Ribble Valley Borough Council
Council Offices
Church Walk,
Clitheroe
Lancashire
BB7 2RA

Phone: [REDACTED]
Email: [REDACTED] [k](#)
Your ref: 3/2025/0650
Our ref: 3/2025/0650/HDC/KW
Date: 17 September 2025

Location: Parsonage Farm Church Street Ribchester PR3 3YE
Proposal: Demolition of existing dwelling and erection of replacement dwelling with new gated entrance and associated planting
Grid Ref: 364308, 435054

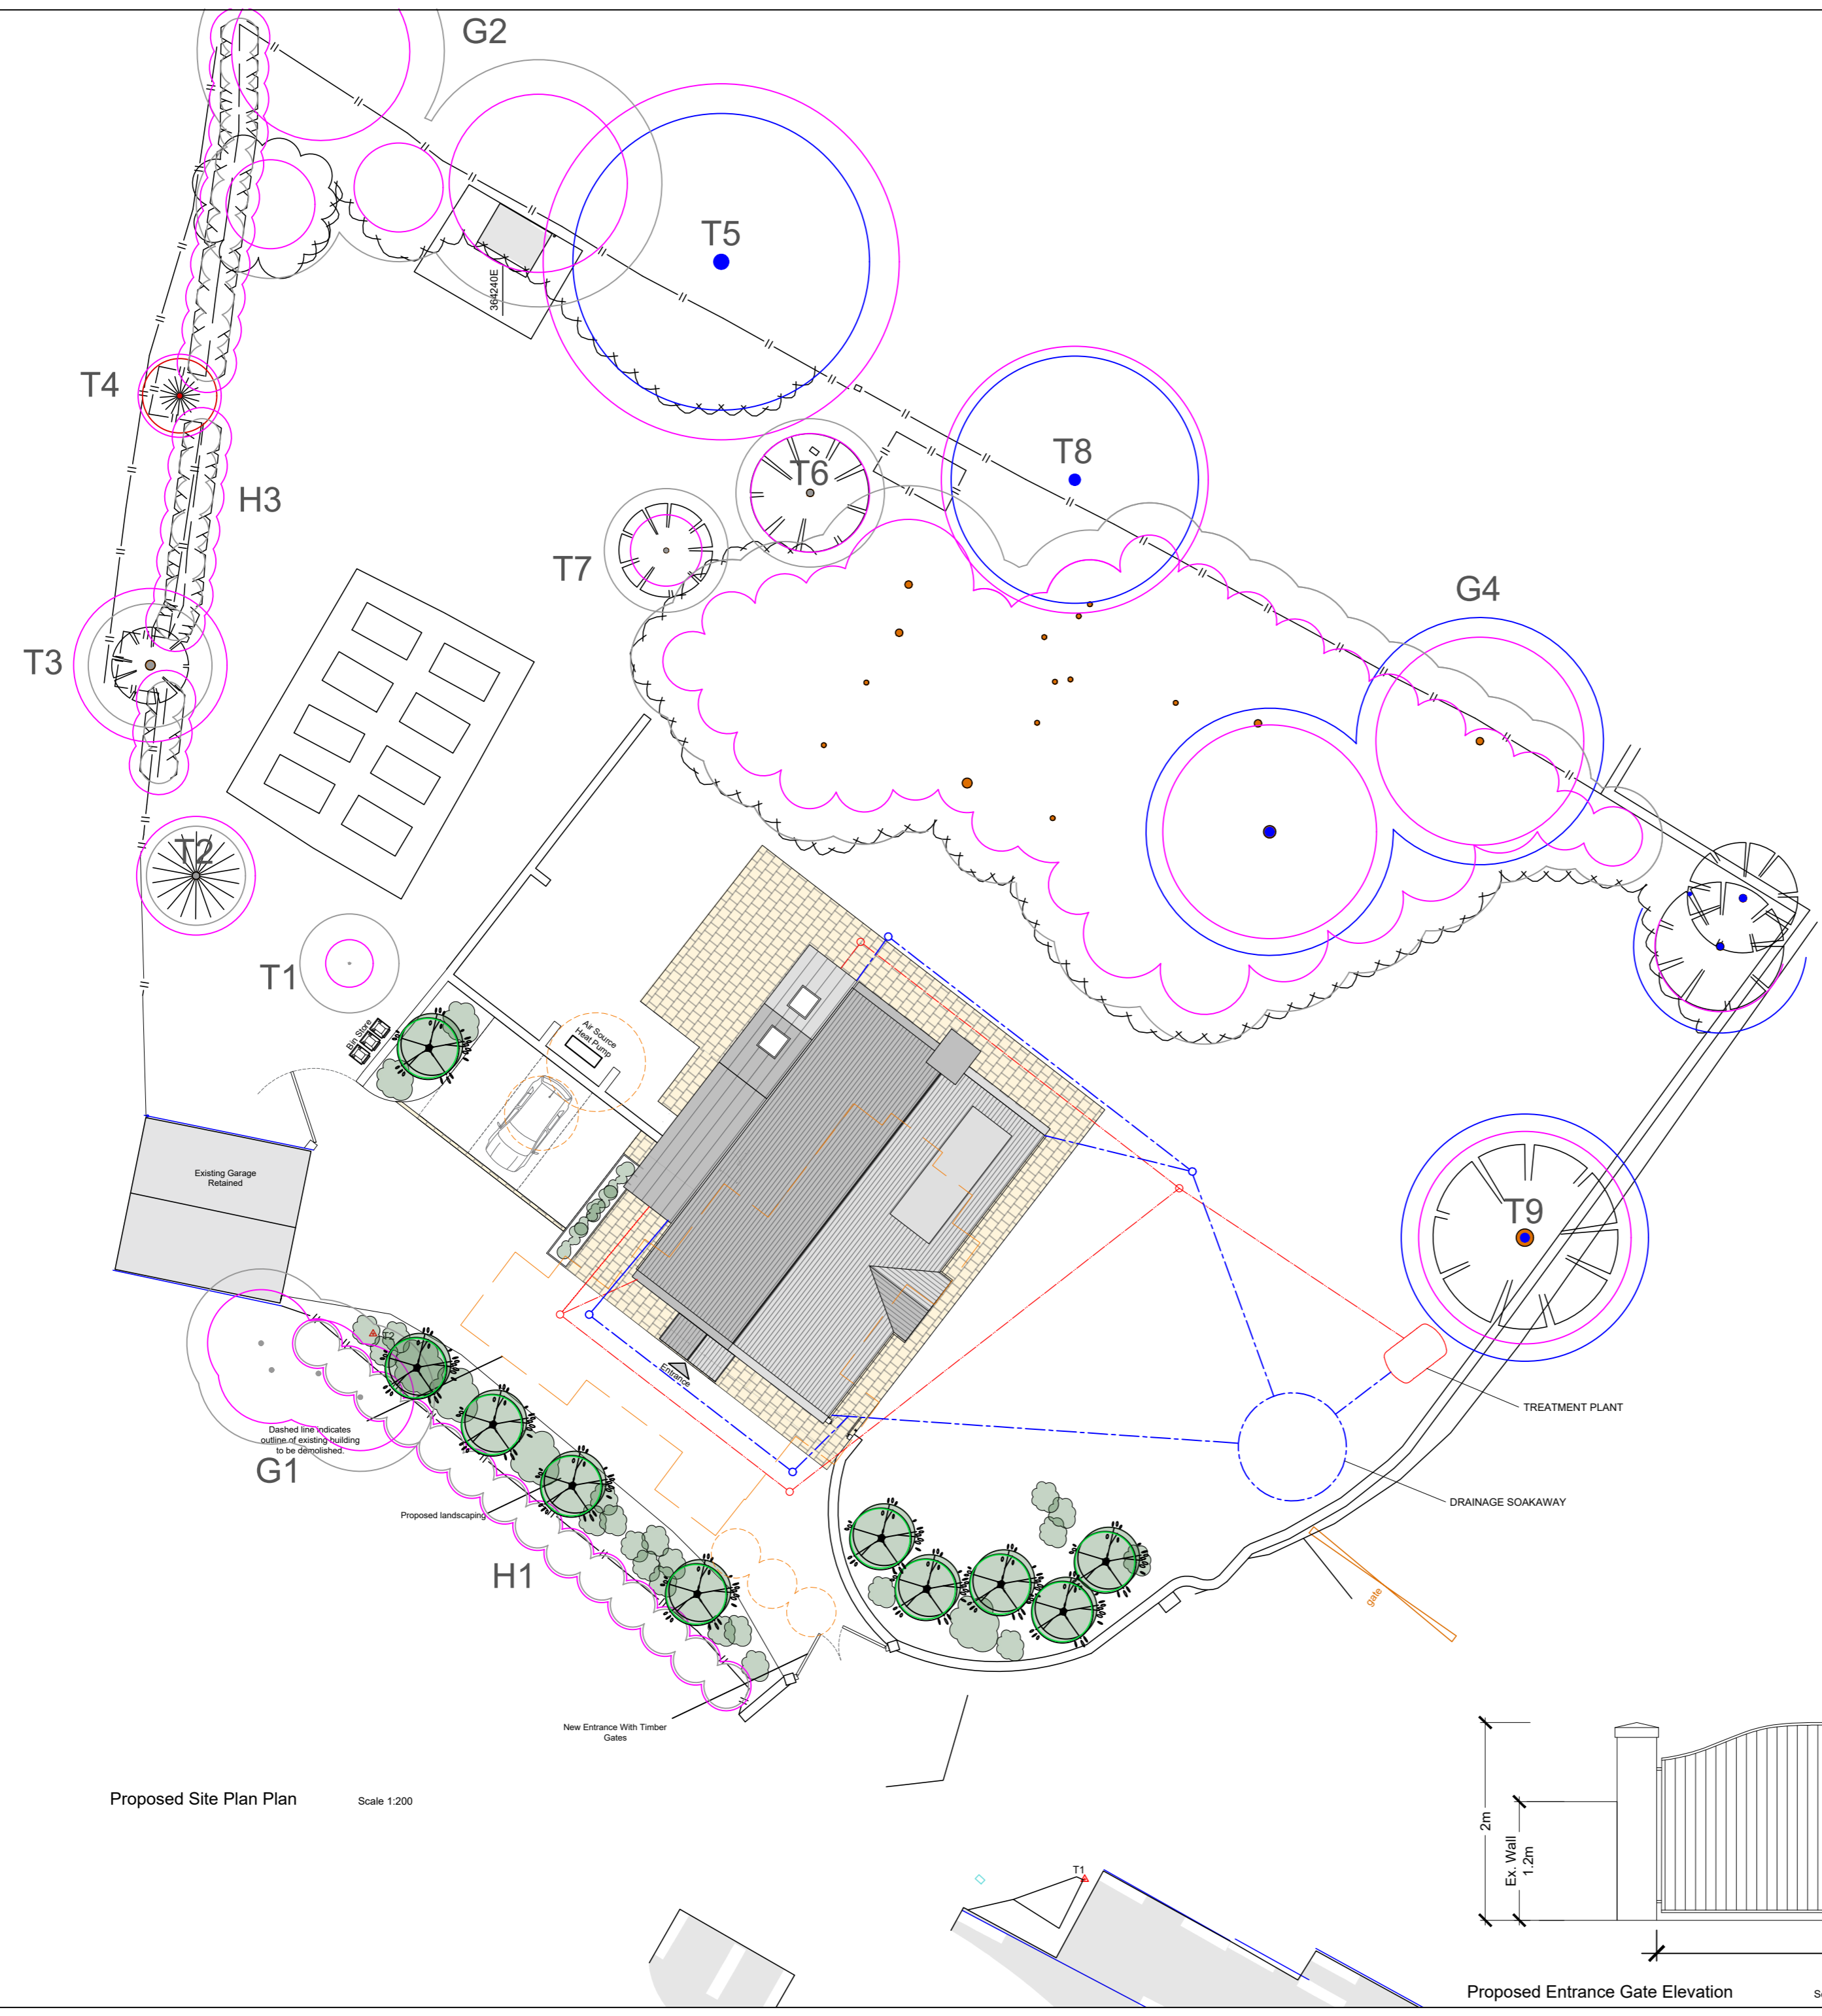
The proposal includes a gate situated at the edge of the development. It is recommended that the gate be set back 5m into the site to avoid any conflict within the private road for those accessing the dwellings, which have been agreed under application 3/2024/0764.

The LHA have reviewed drawing number 6908 P01, Rev A titled Proposed Site Plan and are aware that the parking arrangements for the dwelling comply with the LHAs parking guidance as defined in the Joint Lancashire Structure Plan.

The applicant is also retaining an existing garage and there is room to turn within the site, allowing for ingress and egress in forward gear.
